From: [Haley Mercer](#)
To: ["Chris Cruse"; Justin Turnbull](#)
Cc: [Zach Torrance-Smith](#)
Subject: RE: BL-24-00001 Sligmann
Date: Wednesday, February 21, 2024 11:43:17 AM
Attachments: [2002-16243.pdf](#)
[2016-0488.pdf](#)
[4025_001.pdf](#)
[4030_001.pdf](#)
[B15-P095.tif](#)
[exhibit.pdf](#)

Chris,
In reviewing the Sligmann BLA, we have encountered a bit of a snag. Kittitas Compass GIS shows a County owned parcel (APN:077834) located within the area proposed as Parcel A.

Drawing file: BL-24-00001 Sligmann / 4025_001.pdf

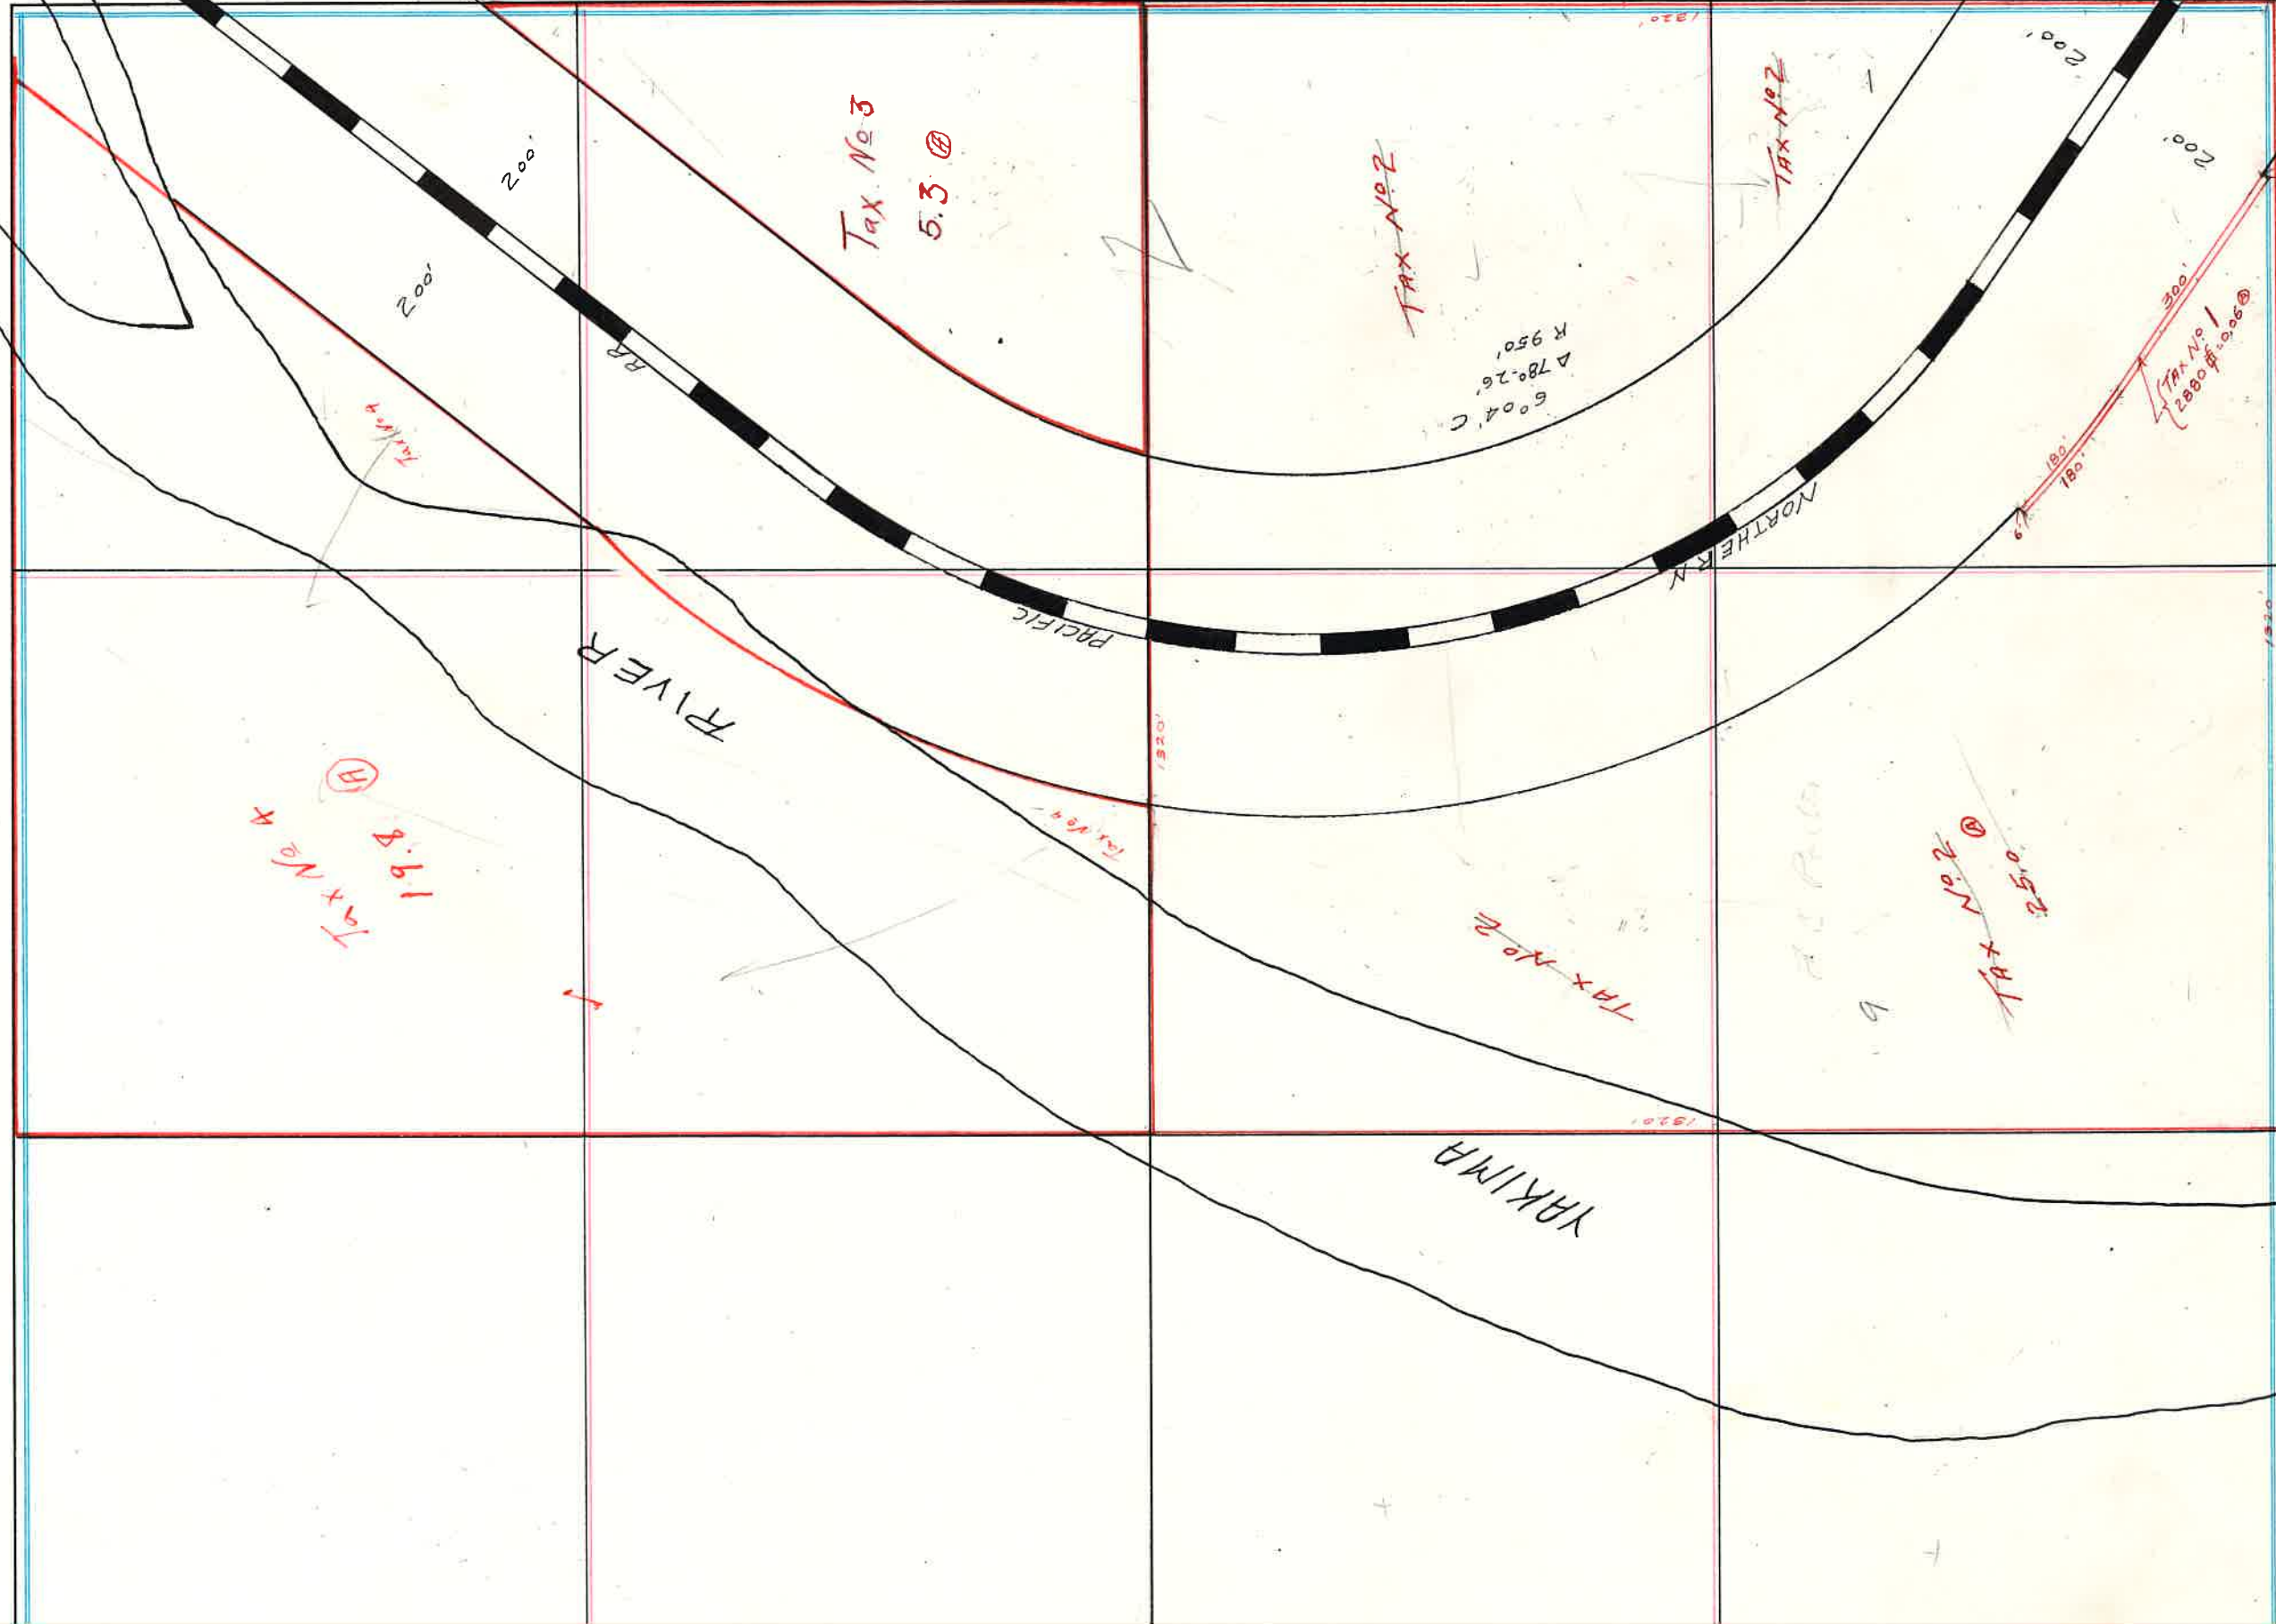
The Tax 1 legal starts to the point 36' N of the SE1/4 corner "Which the point is on the line of the RW for the rail road..." it is not clear to me if the 1987 survey missed representing this sliver or included it within the RW? I do see up close, a dashed line (exception? The survey is not clear on what that represents), however it doesn't match the point of beginning in the Tax 1 legal. It's an old legal description does reference the Tax 1 legal. Which is why we most likely did not question it (and this was pre GIS/COMPAS era)..... Note 3 on that survey refers to Tax 1 legal, but again, the call outs don't lie within the RW..... The record is old, I cannot locate any information from the parcel file for BLA/survey/sales that indicates this sliver should not be where it is on the outside of the RW...

Justin – The tax description has a significant conflict as it calls starting at a point 36' north of the SE corner of SW1/4 and also calls it a point on the RR r/w. The SE corner of SW1/4 falls 168' in the r/w based on our survey and old tax map. Holding the SE corner as per the attached redline does appear to match an old ditch I can see on the aerial. Note 3 of the attached survey describes this strip and found it falls within the RR R/W.

I will be keeping this slivered parcel as it is represented on COMPAS. Unless there's documentation from the railroad that it is in fact in their RW or a new legal description/survey is provided otherwise.
